Response on behalf of Huddersfield Civic Society to Planning Application 2021/93674:  
Partial redevelopment of Greenhead college

Issued for planning	S2	P24	CLO	IWA	24/11/21
Issued for planning	S2	P23	CLO	IWA	23/11/21
2 additional trees added	S2	P22	IWA	IWA	18/11/21
Revision	Status	Rev	Author	Aprvd	Date

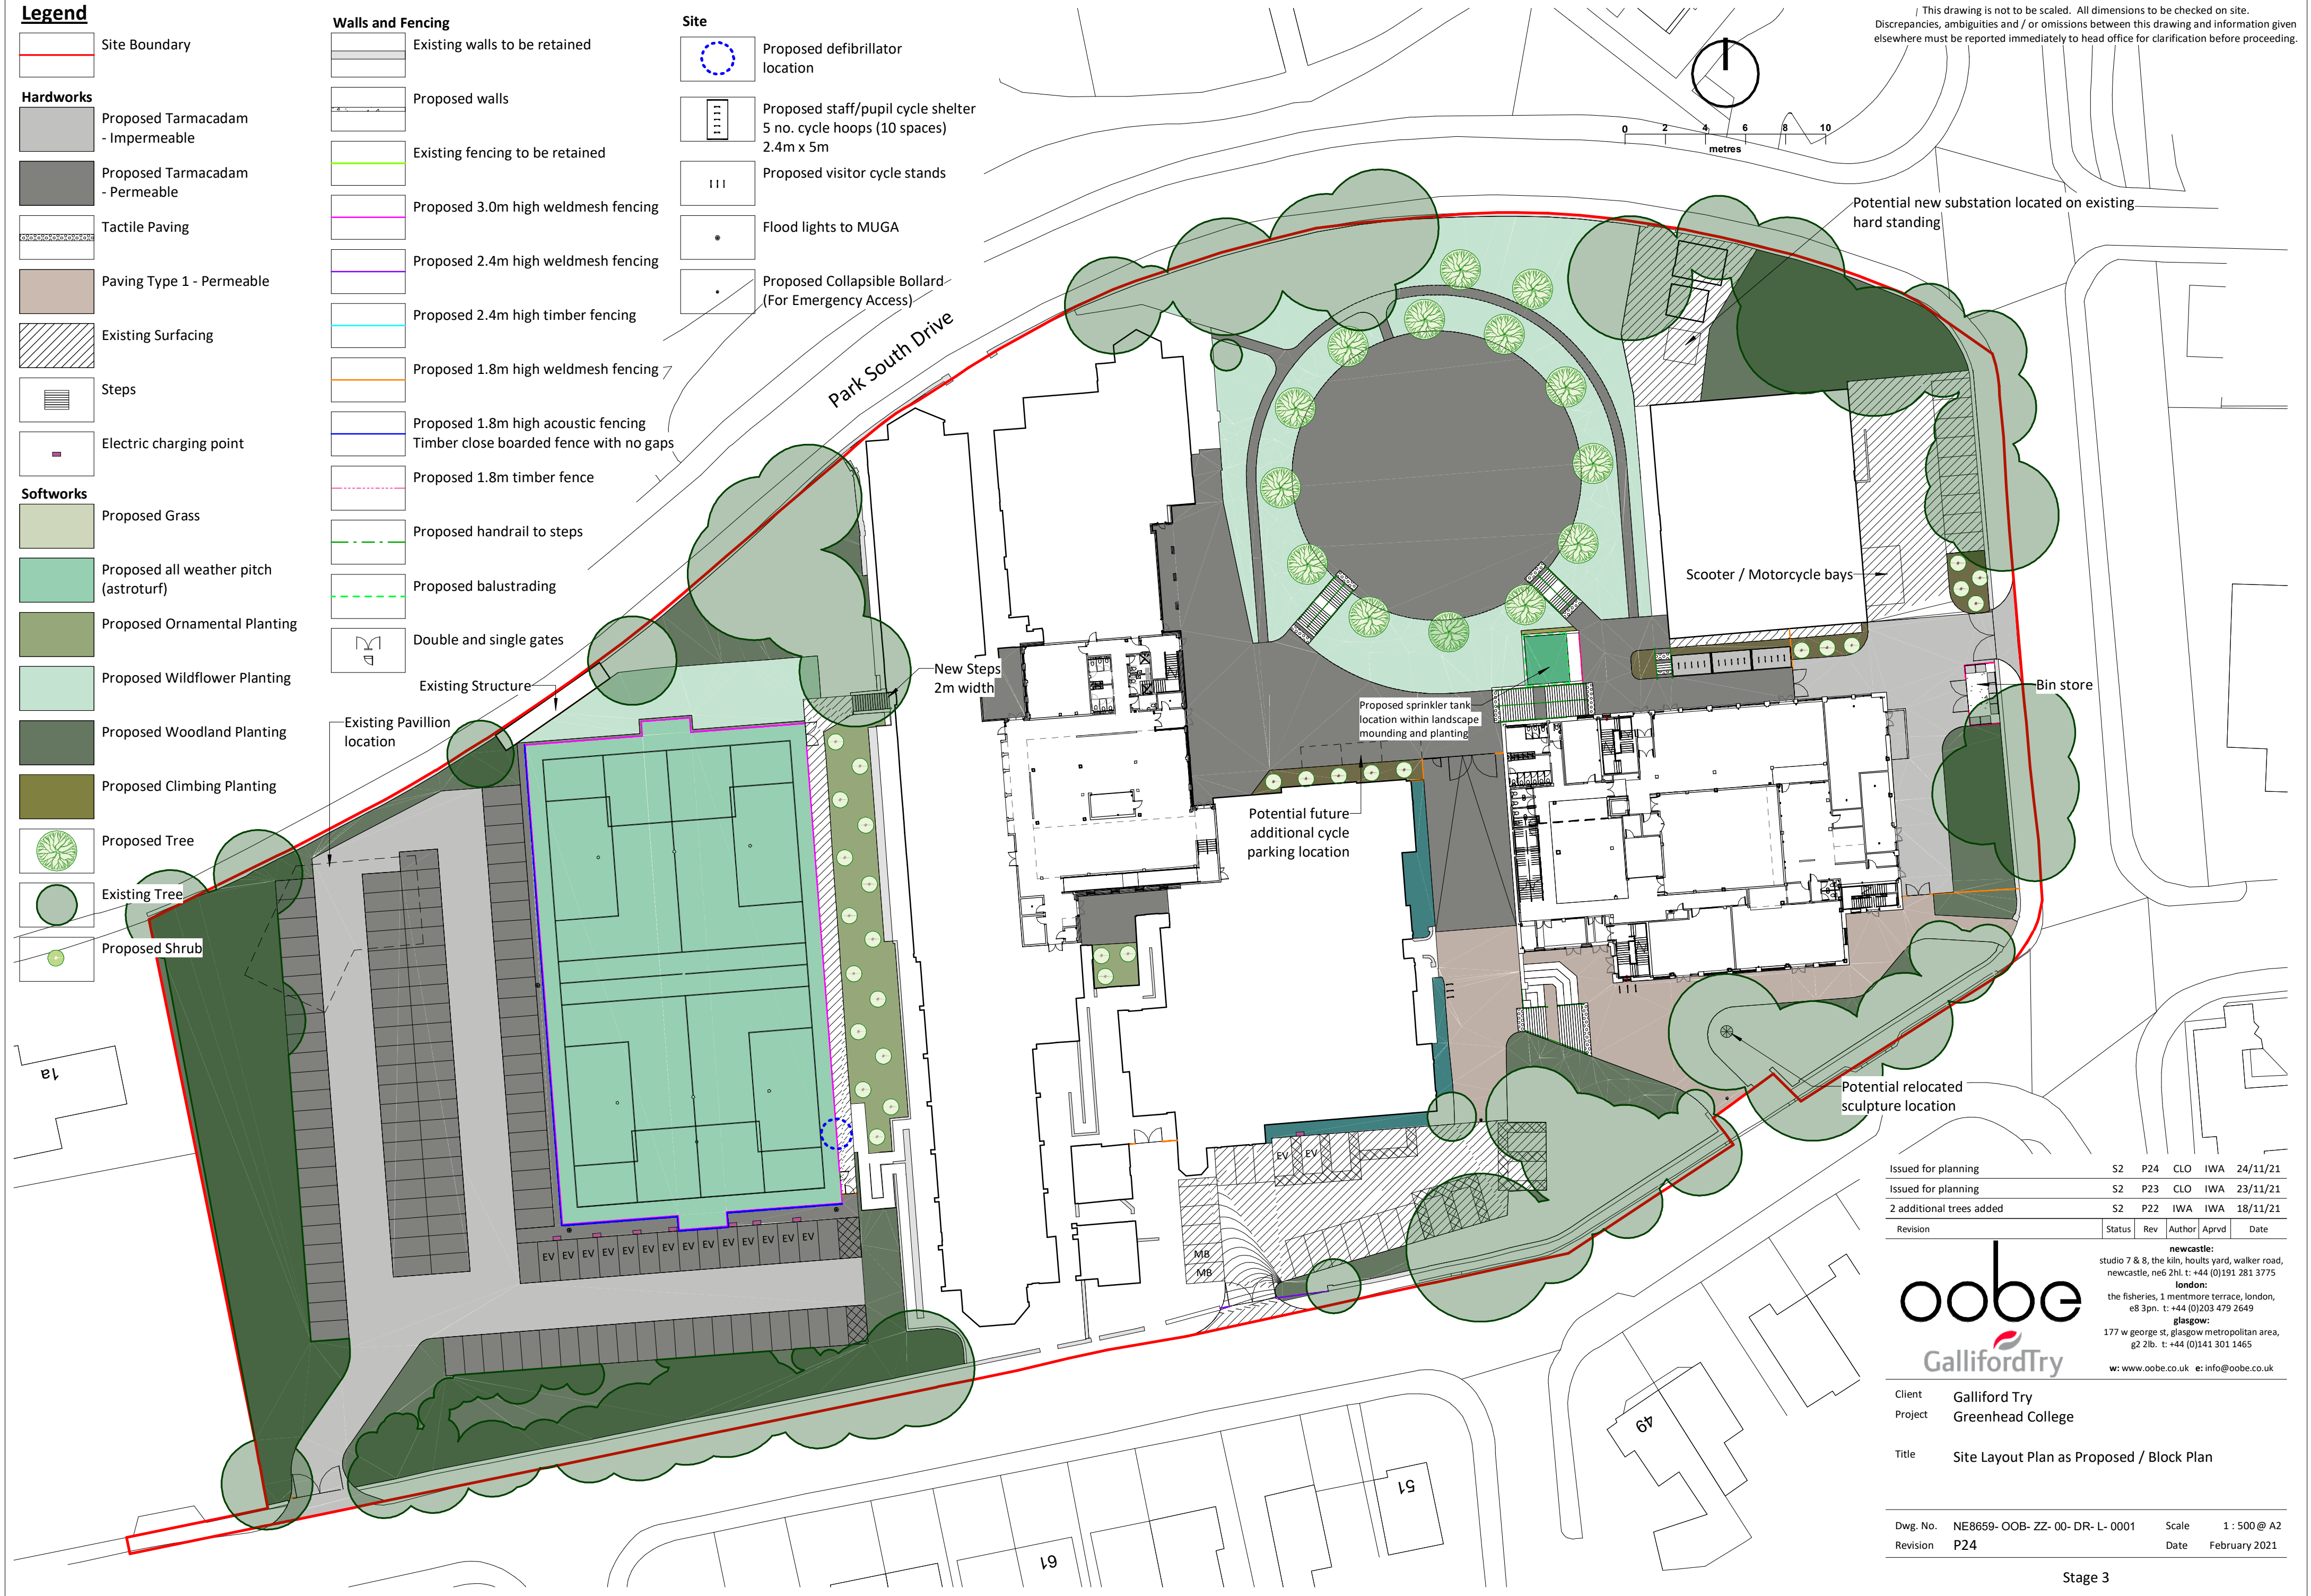
- 1) The very low level of electric vehicle charging points (16) to be included in the construction of new car parking for c160 vehicles
- 2) The very low level of 'long stay' cycle provision: only 30 cycle places for 2600 pupils plus c185fte staff. This is despite Kirklees Council proposing significant improvements to cycle routes on nearby Trinity Street and across the ring road to the town centre
- 3) We can find no mention of how the carbon impact from the proposed tree felling and scrub removal is to be mitigated
- 4) The lack of clarity behind the claim in the summary of the submitted Ecological Impact Assessment (EIA) that 'the proposed development delivers a net gain for biodiversity'.

In the first two cases we believe that the proposed provision is woefully below what should be expected in a development intended to last for many years and ask that provision is increased substantially to reflect even short-term goals for increased use of e-vehicles and of Active Travel.

In the fourth case we note that there is no mention in the EIA of the number of trees to be felled as per the AIA. Given the felling of trees and an overall increase in landscape to be covered in concrete or tarmac, we would hope that the workings behind a claim of biodiversity INCREASE would be clear to all readers. Kirklees Local Plan Policy LP30 requires there to be Biodiversity Net Gain and we ask that calculations are resubmitted that match the reduction in tree cover and increase in concrete/tarmac cover to 'habitat units' in a manner that the reader can follow.
